## SCOTT M MCGEE PE, LLC

1/21/2014

Re: Atrisco Apartments (H11/D068)

A Grading Certification was submitted 10/23/13 with a request for a Certificate of Occupancy. Your concerns noted 10/25/13 are addressed as follows:

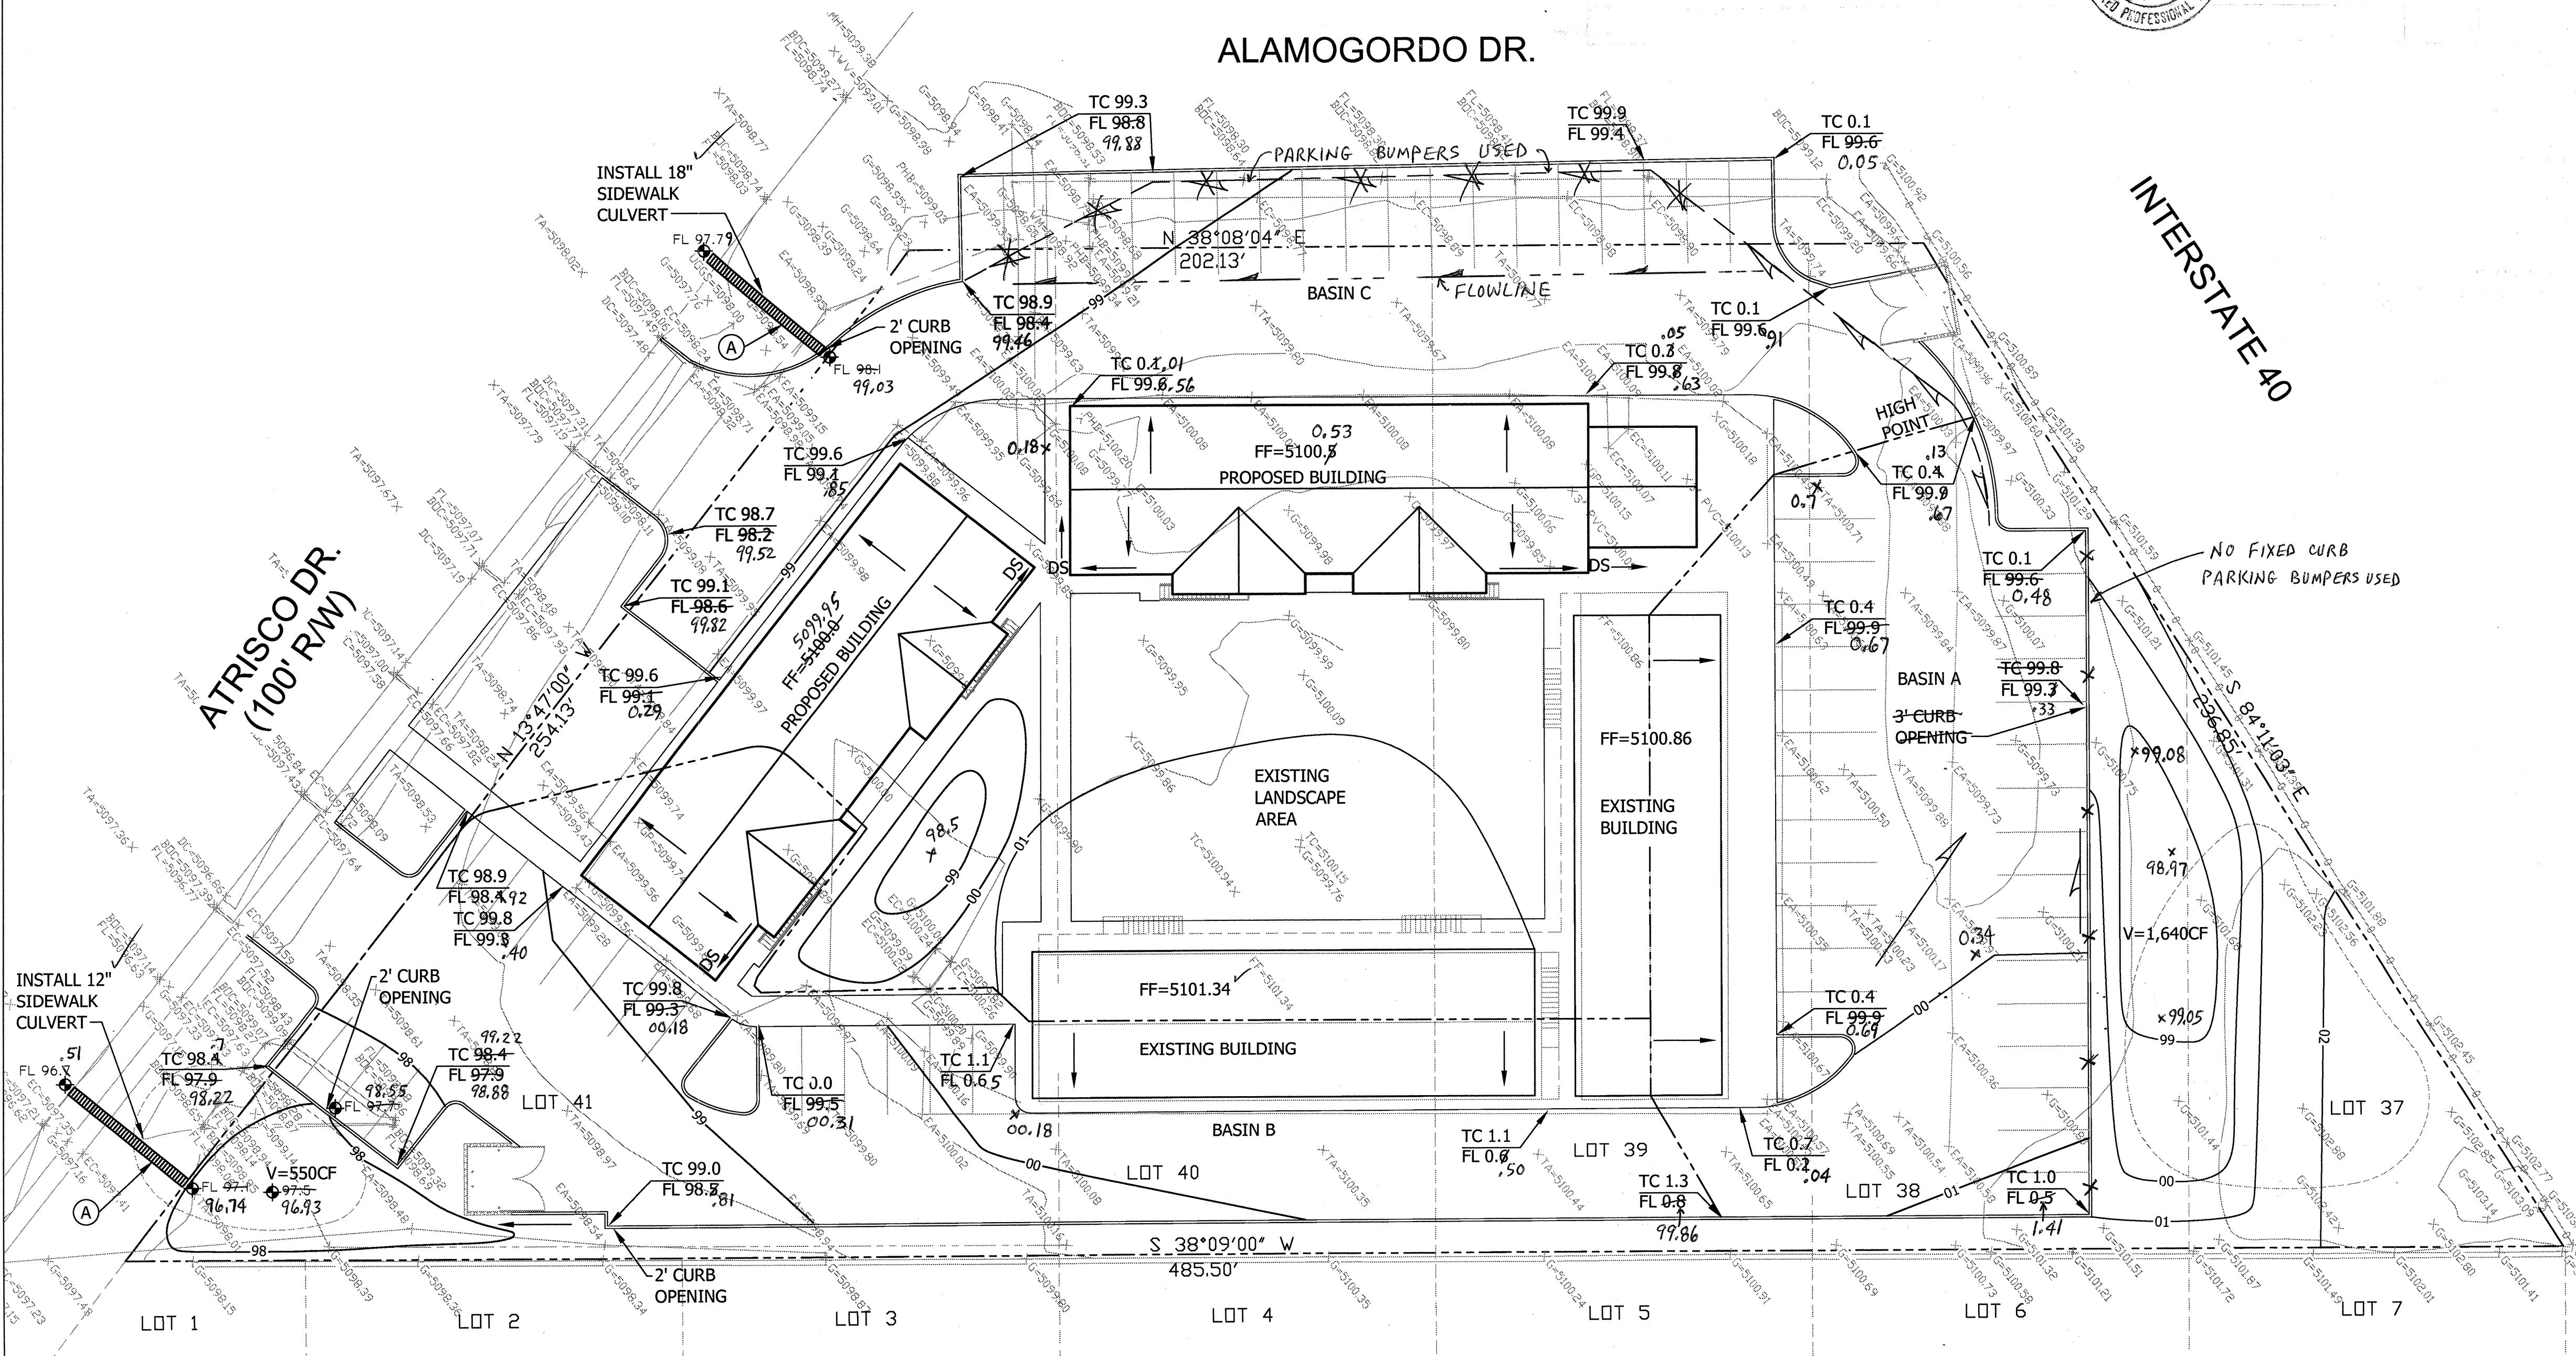
The Owner has stated that where asphalt curbs were placed adjacent to buildings, curb openings will be cut when and where needed. The Owner will also be responsible for any runoff flowing toward the buildings (water will enter the maintenance room and pond against the north side of the building facing I-40), and will take any appropriate actions necessary to protect the structures from excess runoff. Rain gutters have been installed over walkways.

Parking lot elevations (east of the easterly building), are represented by the existing asphalt spot elevations as the old paving was not removed and replaced as designed.

The sidewalk culvert plates extend from the Atrisco Drive curb face to the property line as required to get the green tag approval for the S. O. 19 permit.

The playground north of the site was added during construction and was not part of the original grading design. The 18" depth of the playground material has considerable void space and will act to retain all rainwater that falls on it--effectively reducing runoff from this area.
